CITY OF ALBUQUERQUE

November 15, 2021

Re: Champion Xpress Car Wash
1520 Juan Tabo Blvd. NE
Traffic Circulation Layout
Engineer's Stamp 11-03-21 (J22-D071)

Sheet No.: C-2.0

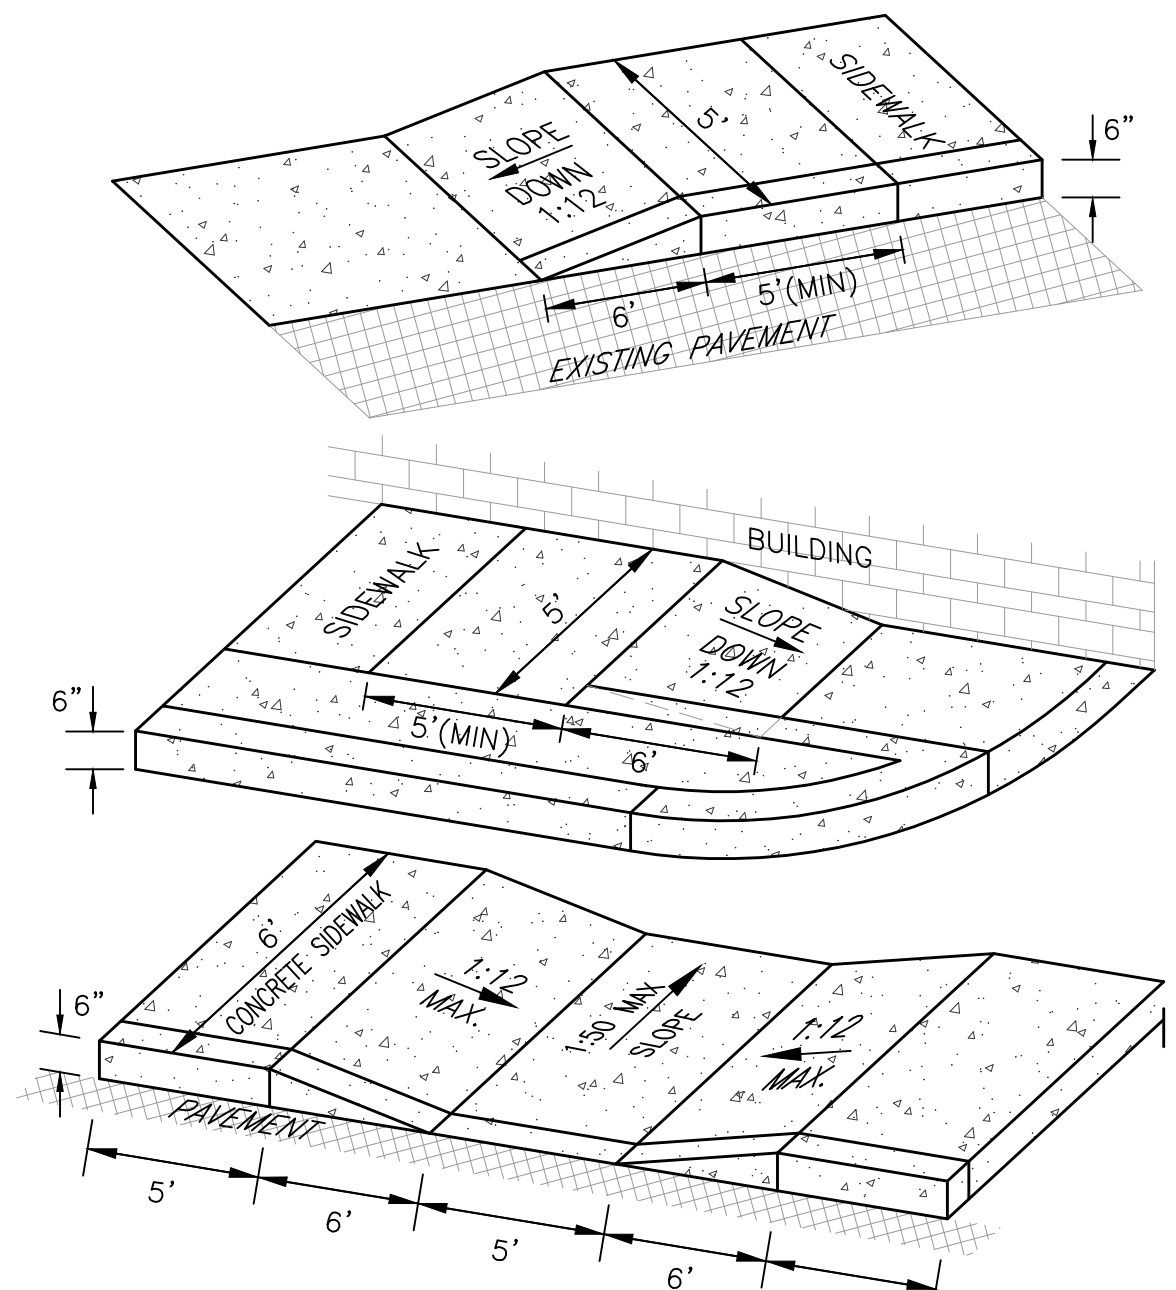
1. List the number of parking spaces required by the IDO as well as the proposed number of parking spaces including bicycle and motorcycle parking.
2. Identify all existing access easements and rights of way width dimensions.
3. Identify the right of way width, medians, curb cuts, and street lanes widths on Juan Tabo.
4. Maximum access width for arterial, collector, and local streets are as follows:

- Juan Tabo is Principal Arterial.
5. Jaun Tabo Proposed Entrance:
 - Provide entrance details. Reference COA standard DWG.
 - The proposed entrance Island needs to located on the private property. Is this Island will obstruct the efficiency of egress and ingress traffic?
 - Provide the dimension from the face of the curb to the adjasent property line.
 - Provide existing sidewalk width.
 - Please verify if there will be any conflict between northren leg segment of driveway access and existing Stormwater Inlet.

- Southern leg driveway: Please verify if there will be any interfere between proposed ADA ramp and adjacent property line.
 - It appears you are proposing a tight radius. Per DPM curb return radius is 15 ft for cars only. Radius for delivery trucks, fire trucks, etc. is 25 ft. or larger.
6. Please list the width and length for all existing and proposed parking spaces. Some dimensions are not shown.
7. The minimum parking stall dimensions are:

8. The ADA van accessible parking stall bumper and signage are in conflict. Please address this concern.
9. Princess Jeanne Ave. Entrance
- Provide entrance details. Reference COA standard DWG.

- Due to the limited space, provide paving strips (for NO parking allowed) at the 4th parallel parking space adjacent to the entrance.
10. Label the motorcycle parking spaces by placing (MC) on the pavement of each space.

15. A 5 ft. keyway is required for dead-end parking aisles.

16. Per the IDO, a 6 ft. wide ADA accessible pedestrian pathway is required from the public sidewalk to the building entrances. Please clearly show this pathway and provide details.

17. Per DPM, a 6 ft. wide ADA accessible pedestrian pathway is required from the ADA parking stall access aisles to the building entrances. Please clearly show this pathway and provide details.

21. The minimum drive through lane width is 12 feet with a 25 foot minimum radius (inside edge) for all turns. (A 15 foot radius can be used with an increase in lane width to 14 feet). Please dimension all lane widths and radii.

22. All one-way drives shall have "One Way" and "Do Not Enter" signage and pavement markings. Please show detail and location of posted signs and striping.

23. Provide details for all pavement markings and striping.
24. Please provide a sight distance exhibit
25. Show the clear sight triangle and add the following note to the plan: "Landscaping and signage will not interfere with clear sight requirements. Therefore, signs, walls, trees, and shrubbery between 3 and 8 feet tall (as measured from the gutter pan) will not be acceptable in the clear sight triangle.

26. Please specify the City Standard Drawing Number when applicable.
27. Unused curb cuts must be replaced with sidewalk and curb & gutter. A build note must be provided referring to the appropriate City Standard drawing.

28. Add a note stating "All broken or cracked sidewalk must be replaced with sidewalk and curb & gutter." A build note must be provided referring to the appropriate City Standard drawing.
